Longfield Solar Farm

Statement of Common Ground – Essex County Council, Braintree District Council and Chelmsford City Council (the Host Authorities)

PINS Reference: EN010118

Document Reference: EN010118/EX/8.4(E)

1:1000 @ A3

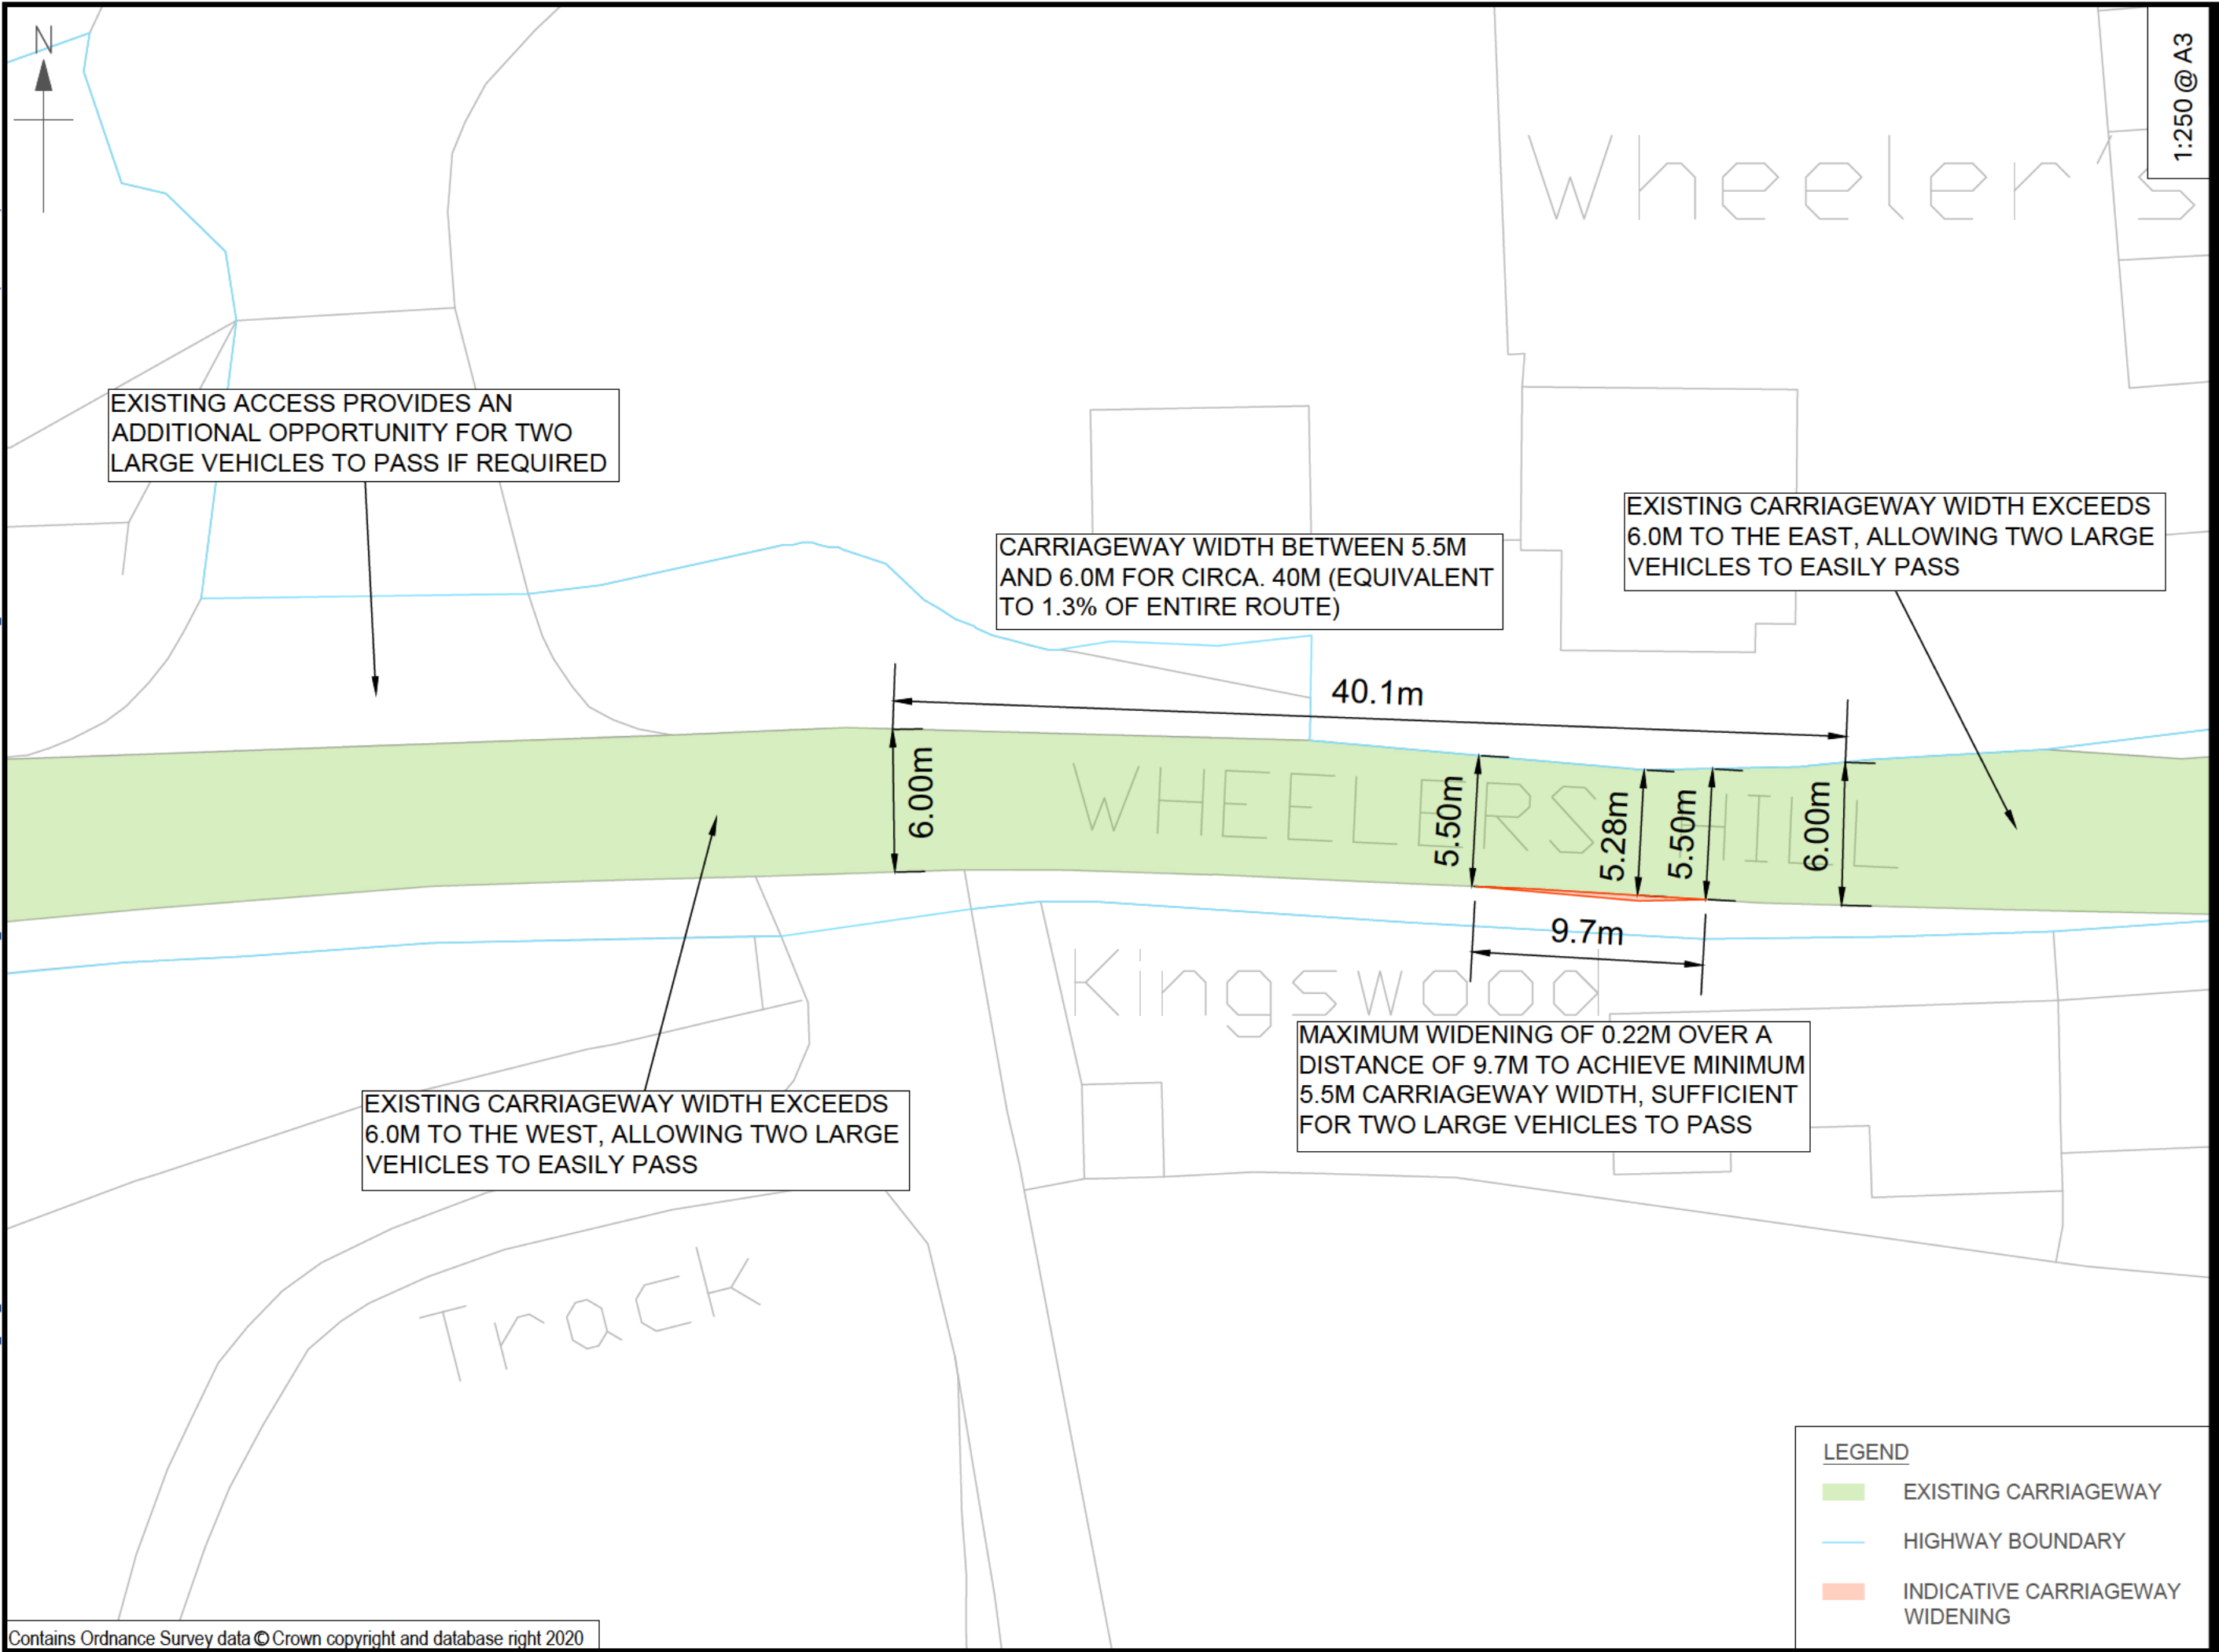
Ref	Sub-topic	BDC's Position	CCC's Position	ECC's Position	Applicant's Response	Status
		<ul style="list-style-type: none"> Proposed carriageway widening on Wheelers Hill, Cranham Road and Waltham Road. Noakes Farm crossing point Locations where permissive routes join or cross existing highway. 			<p>with ECC Highways for review on 12th July 2022. Following this, the only outstanding action was to undertake a RRRAP assessment to determine whether safety fencing/ barriers are required on Waltham Road as a result of Longfield Solar Farm which can be accommodated within the highway or land within the control of the Applicant. The RRRAP assessment was carried out in October 2022 and the Designer's Response was updated to reflect the findings/ recommendations. The updated Designer's Response and RRRAP was shared with ECC Highways on 1st November 2022.</p> <p>The remaining points picked up with the Stage 1 RSA have been addressed as part of the Designer's Response and as such no further actions are considered to be required following the completion of</p>

Ref	Sub-topic	BDC's Position	CCC's Position	ECC's Position	Applicant's Response	Status
TRA-05B	Condition Survey	ECC: ECC considers that despite the widening to 6 metres, where possible there remains the possibility that additional traffic could impact on the condition of the highway asset and verges adjacent to the highway. The Construction Traffic Management Plan should include reference to before and after studies for any vulnerable sections of the highway asset being required together with a programme for reinstatement of any defects both during and after the construction period.			A condition survey will be carried out on Wheelers Hill, Cranham Road and Waltham Road (125m section between Cranham Road and the proposed site access) pre-construction, during construction and post-construction, to identify any defects that arise to highways assets/ verges during the construction phase of the Scheme for re-instatement. This will be secured within the Framework CTMP which has been updated and resubmitted accordingly.	ECC: Agreed following the meeting on 26 th September 2022 and on the basis that the Framework CTMP has been updated.
